Rezoning Transportation Analysis

Petition Number: 2021-079

| Date | Description |
|------------|--------------------|
| 08-02-2021 | First Review (WB) |
| 09-17-2021 | Third Review (KP) |

DRAWING NO.: **RZ-01**

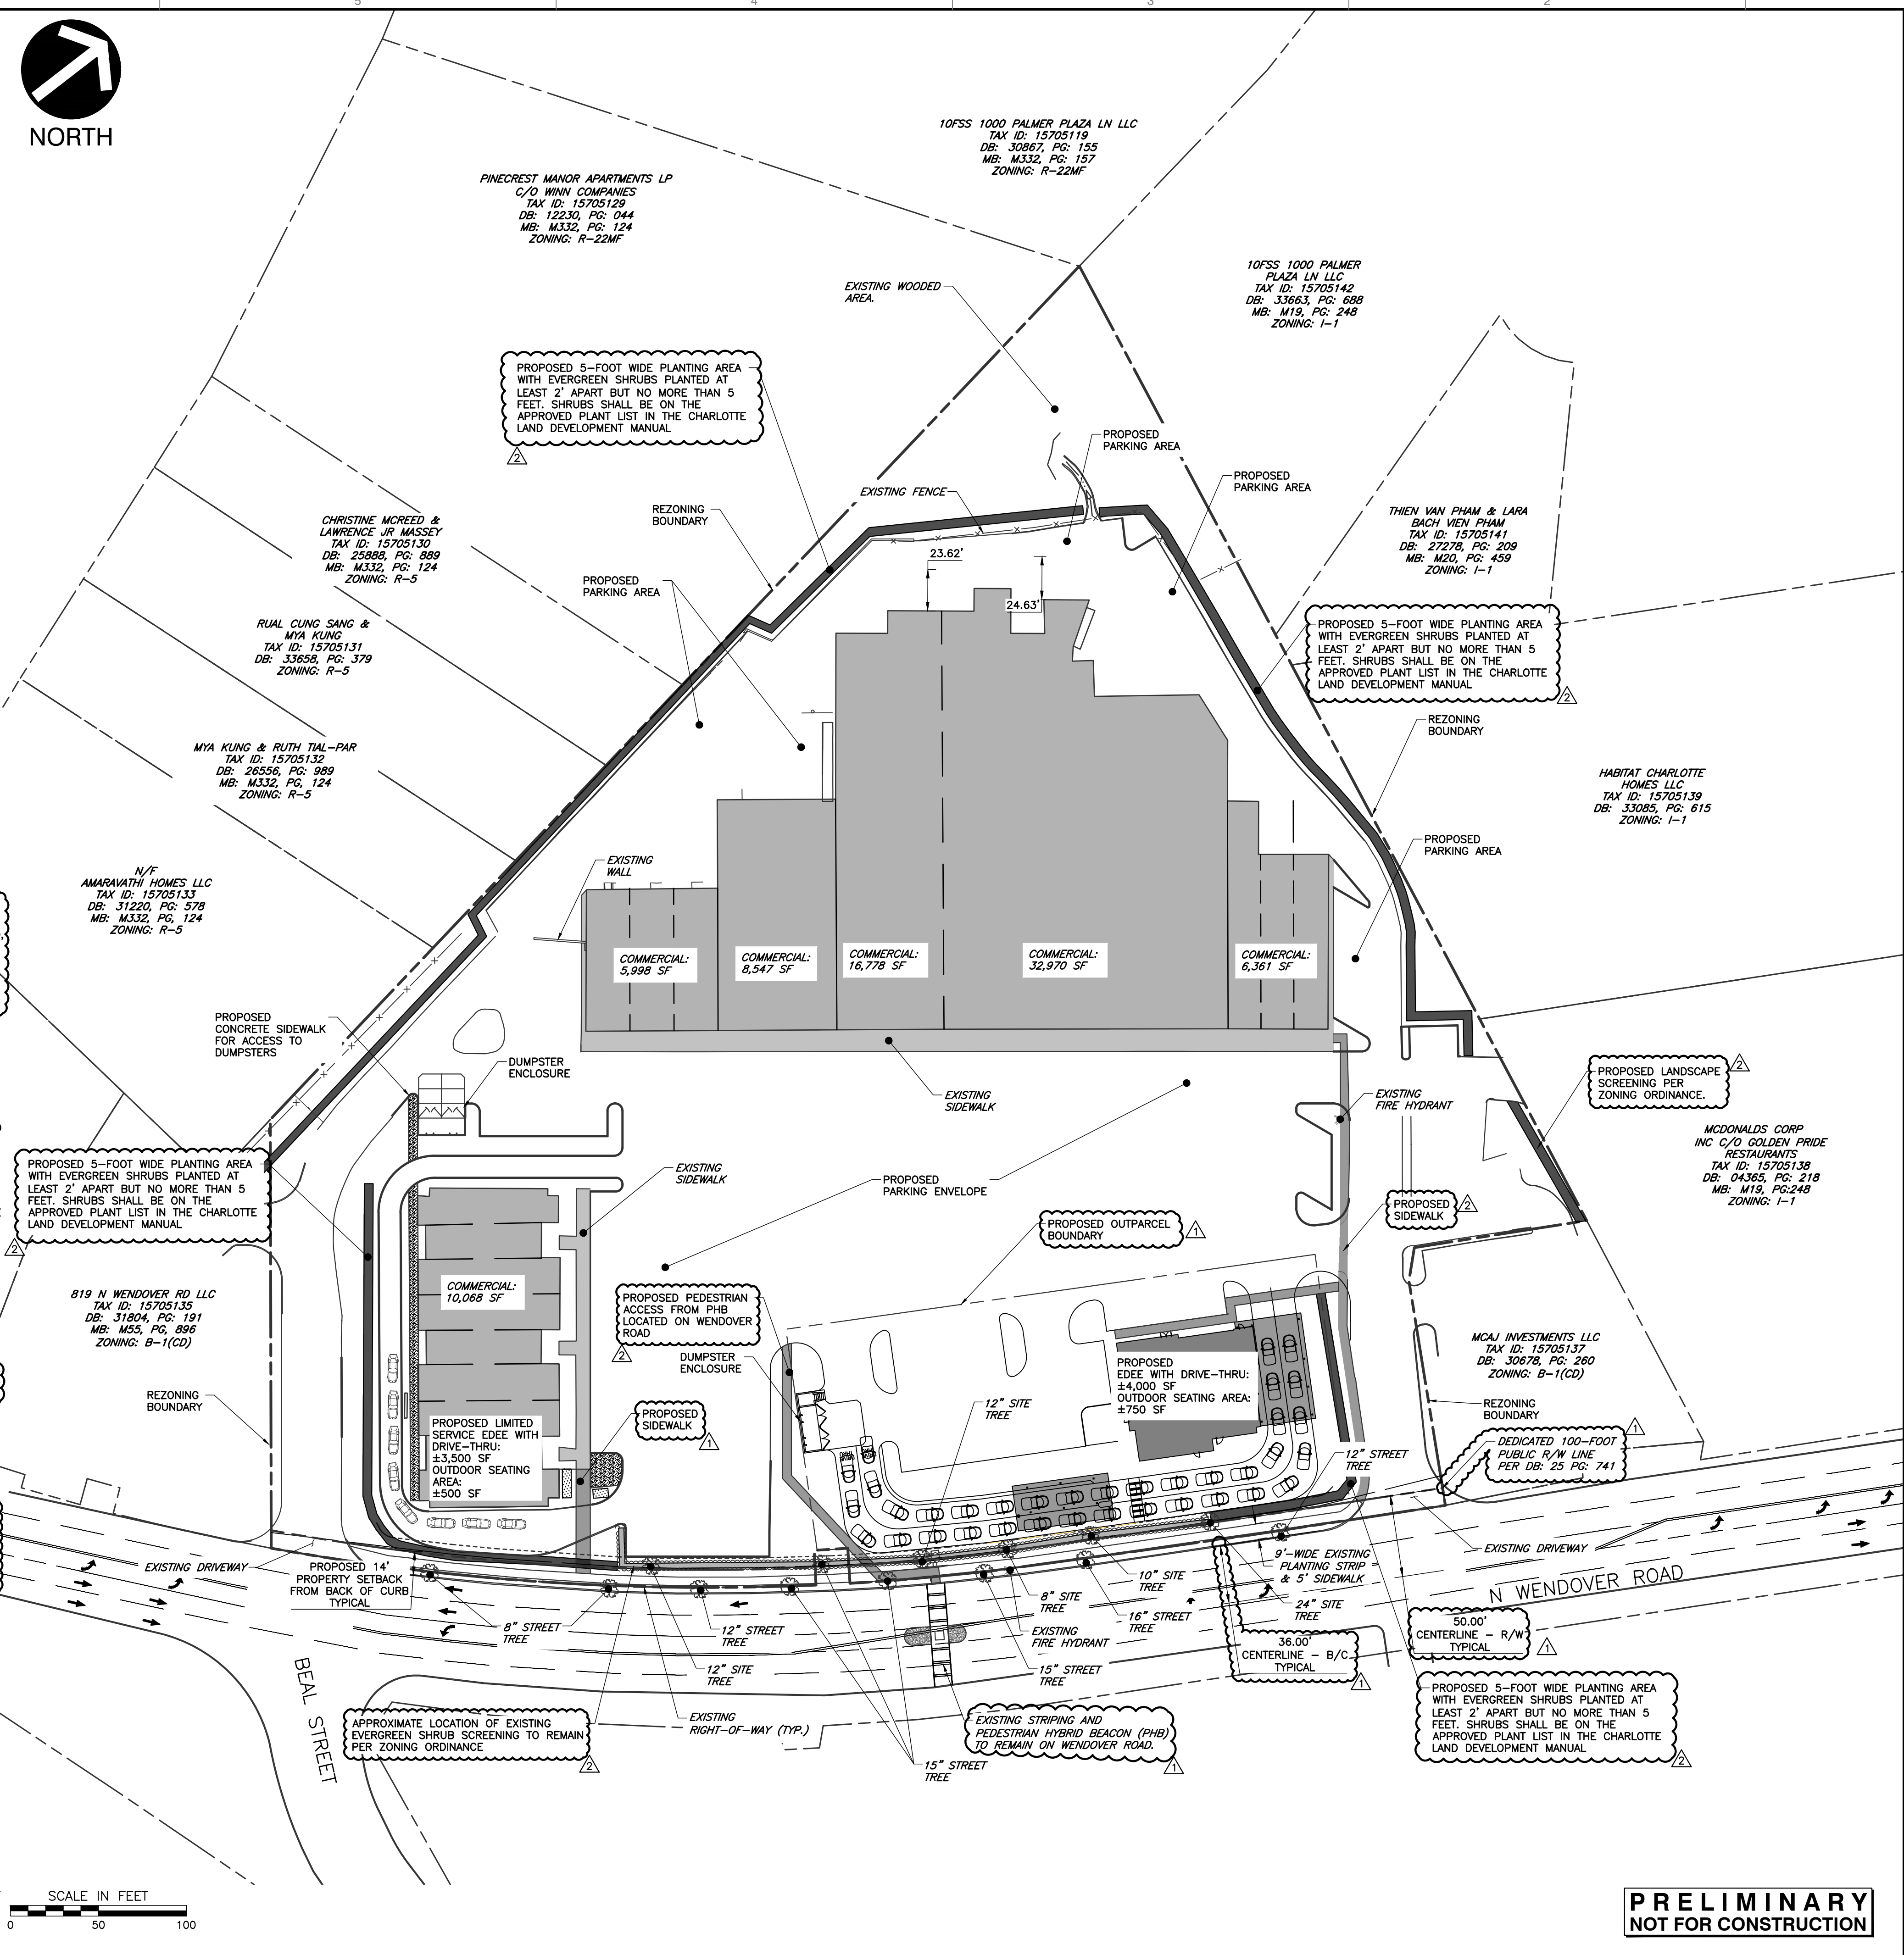
4. **Outstanding Comment from 08-02-2021:** Site plan and conditional note(s) revisions are needed to commit to installing a 12' multi-use path with an 8' planting strip along the site's frontage of Wendover Road to meet the Charlotte BIKES Policy.

7. **Outstanding Comment from 08-02-2021:** Add a site plan note specifying dedication and fee simple conveyance of all rights-of-way to the City before the site's first building certificate of occupancy is issued.

9. **New Comment 09-17-2021:** Add conditional note "All public roadway improvements will be subject to the standards and criteria of CDOT and NCDOT, as applicable, to the roadway improvements within their respective road system authority. It is understood that such improvements may be undertaken by the Petitioner on its own or in conjunction with other development or roadway projects taking place within the broad south eastern Mecklenburg area, by way of a private/public partnership effort or other public sector project support."
